# CITY OF ALBUQUERQUE

March 23, 2023

**Re: Lot 20 Block 5 SAD 228  
Volcano Cliffs Subdivision Unit 19  
7831 Urraca Rd. NW  
Grading and Drainage Plan  
Engineers Stamp Date 4/17/2022 (D10D003H20)  
Pad Certification Date 6/3/2022  
CO Certification Date 3/17/2023**

ENGINEER'S SEAL 4/17/22 DAVID SOULE P.E. #14522	Lot 20 Blk 5 Un 19 VC 7831 Urraca Street NW	DRAWN BY DEM
	GRADING AND DRAINAGE PLAN	DATE 4-15-22
 PO BOX 89924 ALBUQUERQUE, NM 87199 (505) 321-8099		Lot 20 Blk 5 Un 19 VC .dwg
		SHEET # C1
		JOB #

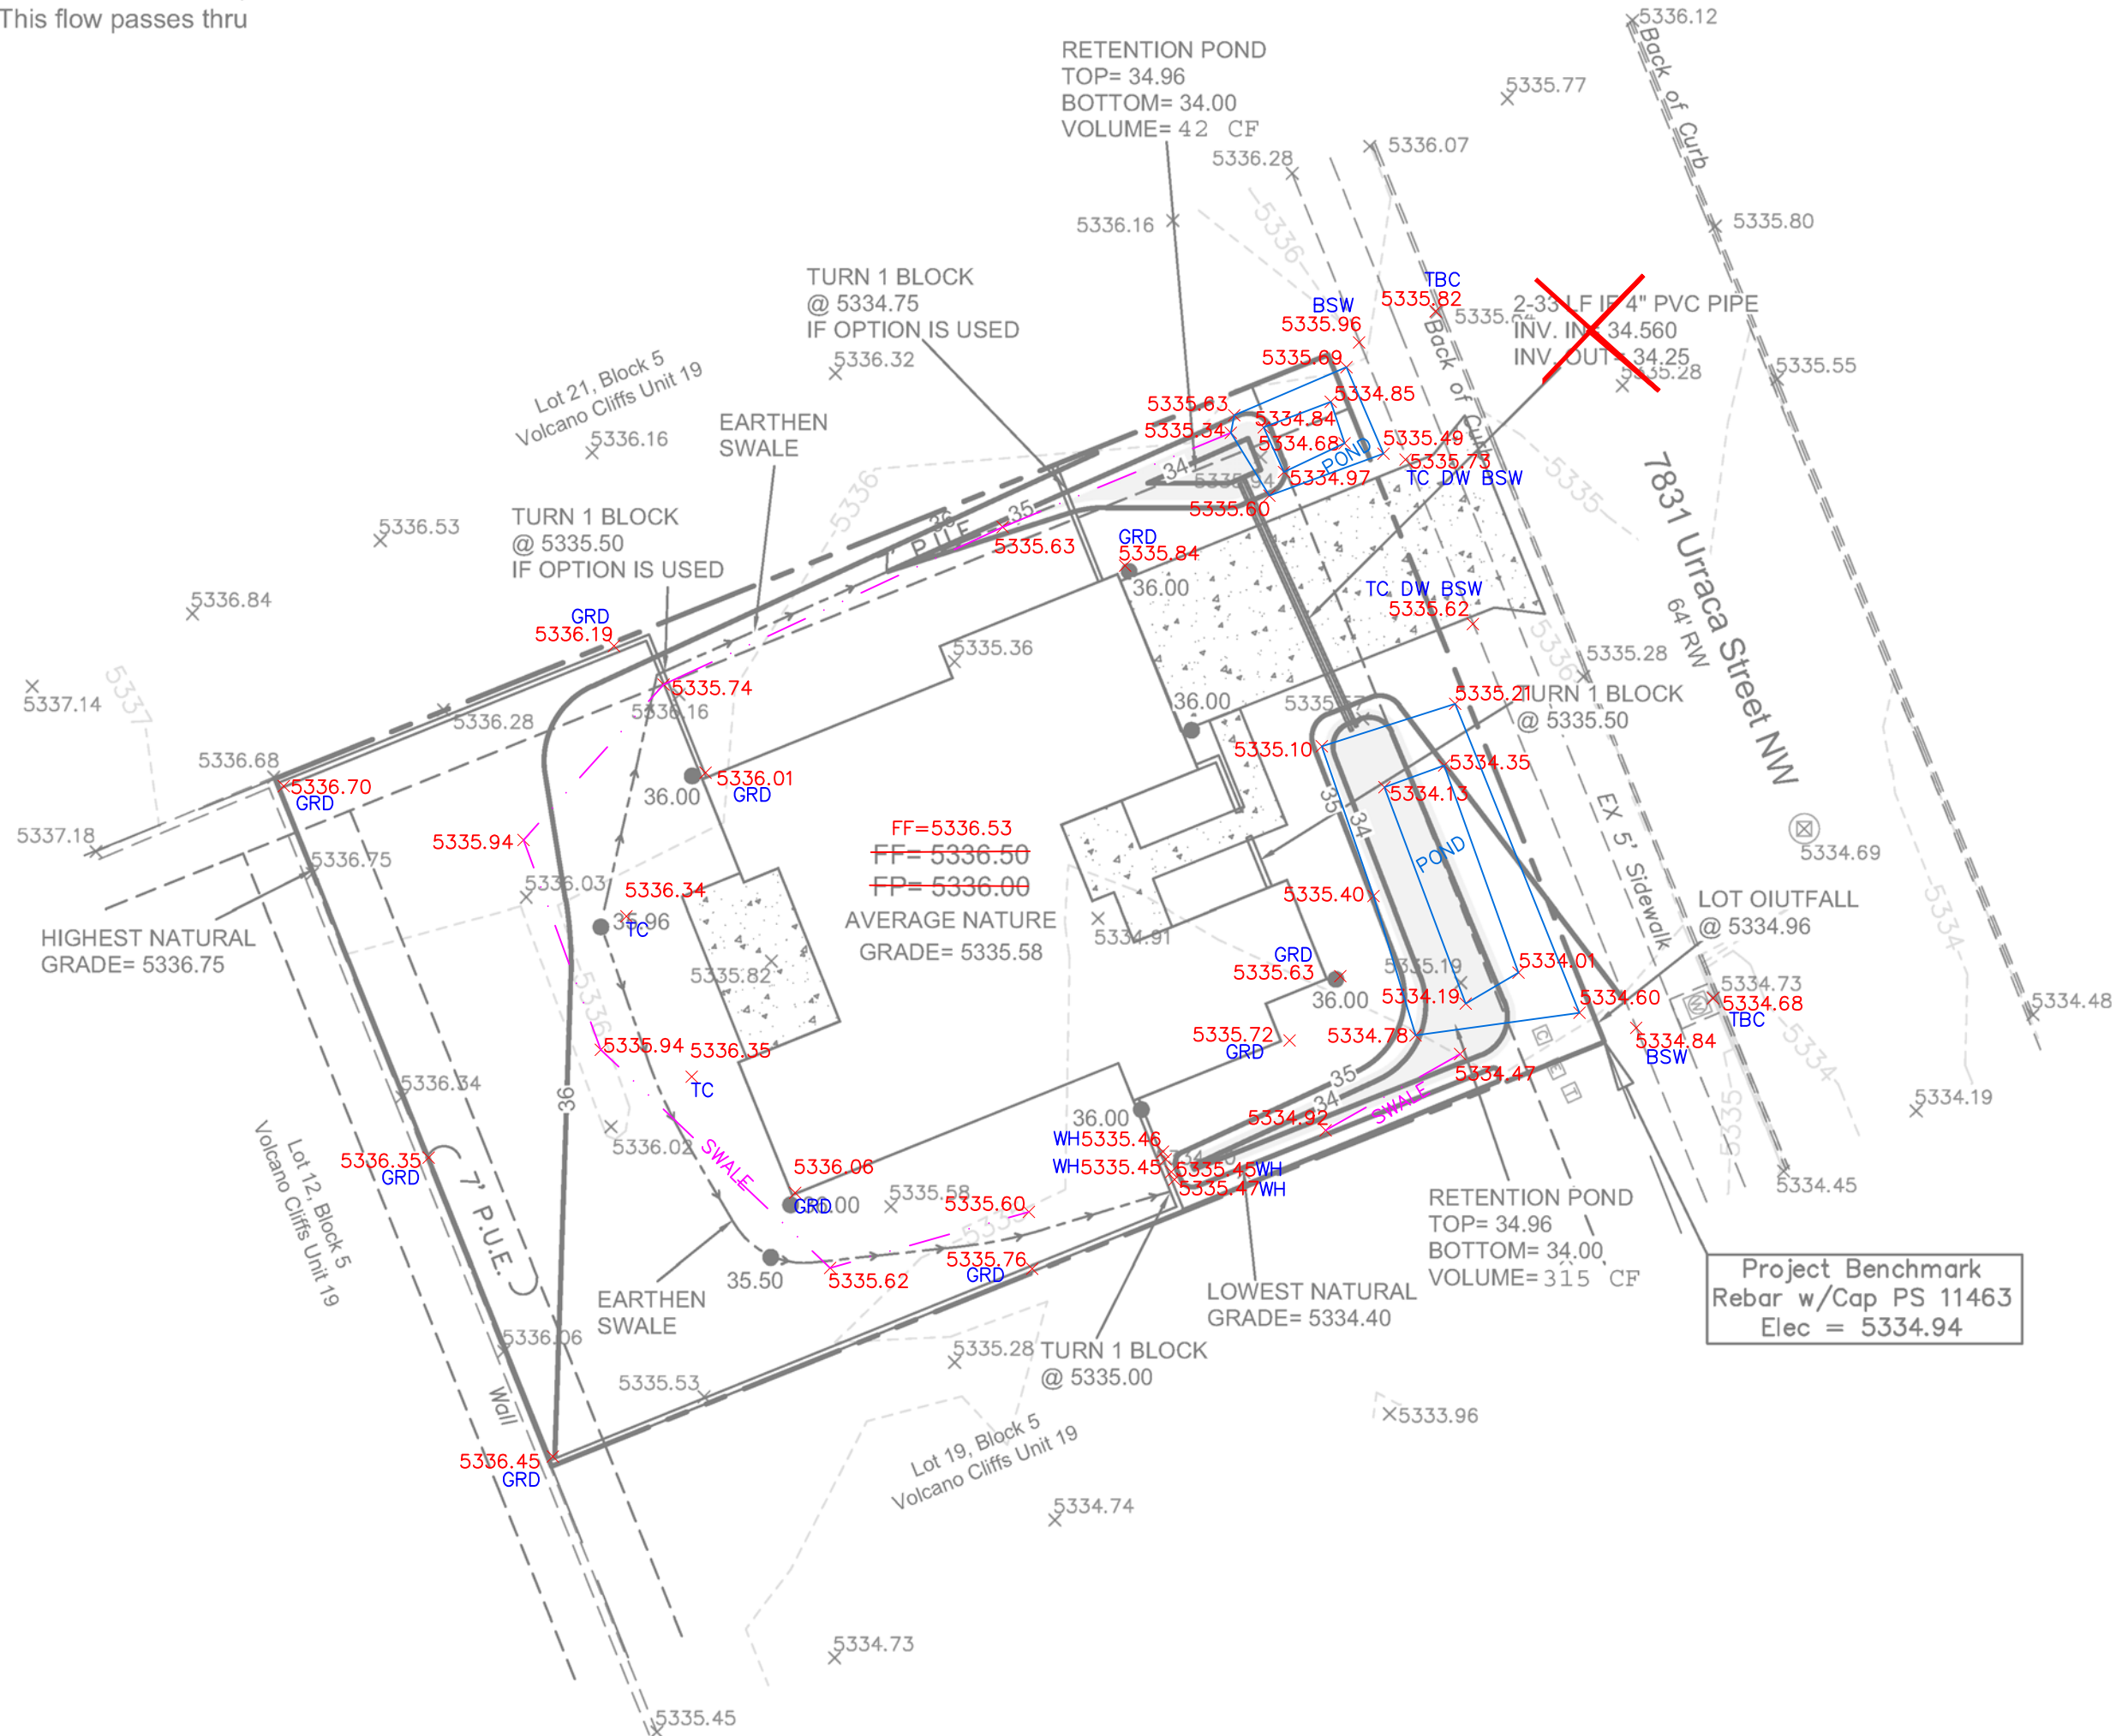
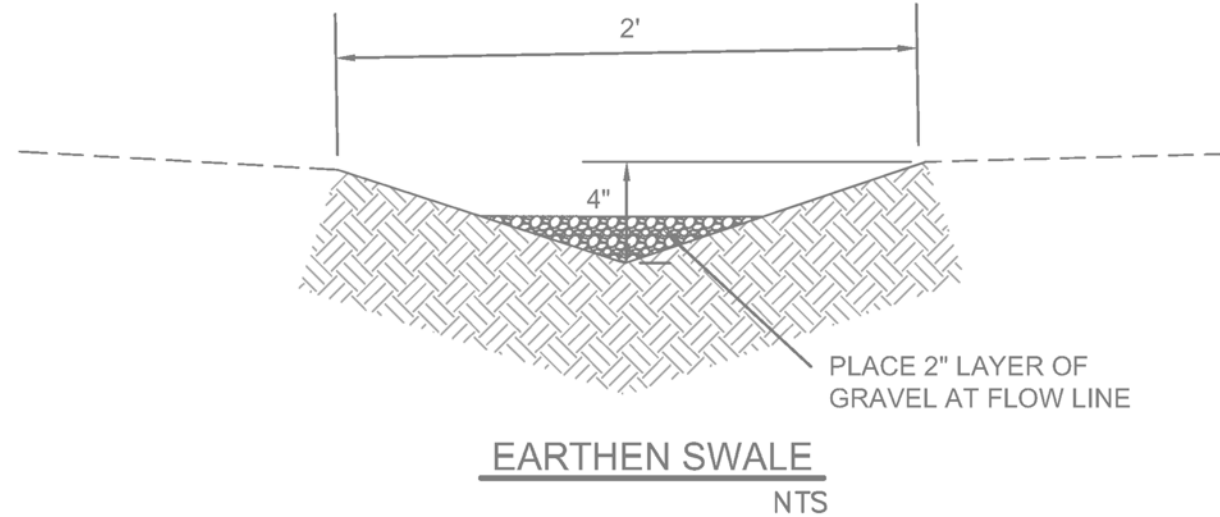
Based on the Certification received 3/22/2023, the site cannot be accepted for release of Certificate of Occupancy by Hydrology until the following comments are addressed.

- All ponding areas and swales need to have gravel in place.
